From:
Sent: 17 July 2026 13:33
To: DC Admin
Subject: Planning Application number 2026/62/91738/E - Representation re change of use of premises

Planning Application number: 2026/62/91738/E - Representation re concerns to change of use of premises at 6 Station Road, Skelmanthorpe

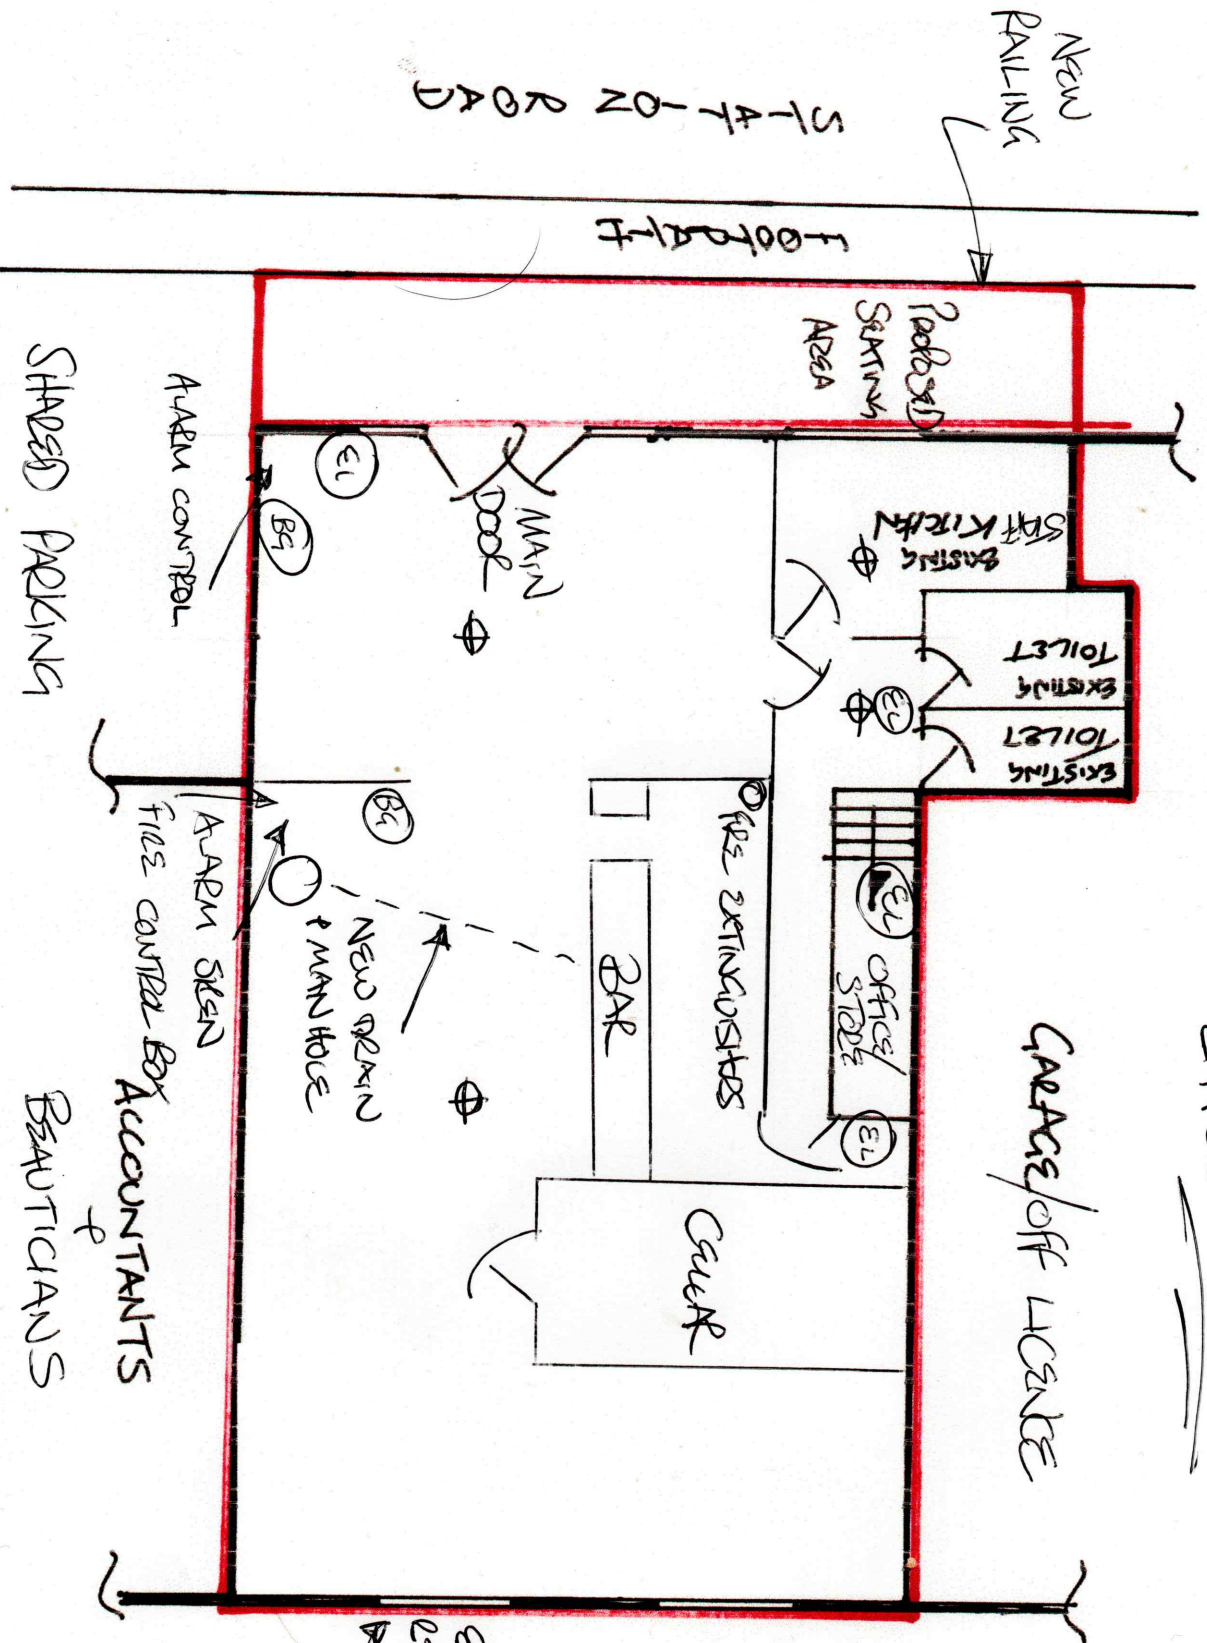
My **third concern** relates to proposal to cook food on the premises. The proposed plan shows a new kitchen area near to the toilets at the entrance to the premises. What is not evident, is any kind of filtration to prevent cooking odours from escaping and pervading nearby properties. If part of the answer lies in opening the windows to the rear and doors to the front of the premises, this would again particularly and significantly affect the rights to clean air of residents with properties on all sides of the building.

My **fifth concern** relates to an emergency evacuation of the premises. The plans appear to show double doors at the entrance and then a single door leading to the bar area. In an emergency, this may cause a crush problem if people needed to leave the premises quickly, as the only route out is through these doors. If again in an emergency, potential customers attempted to vacate the premises through the back windows, there would be a dangerous drop into a garden below.
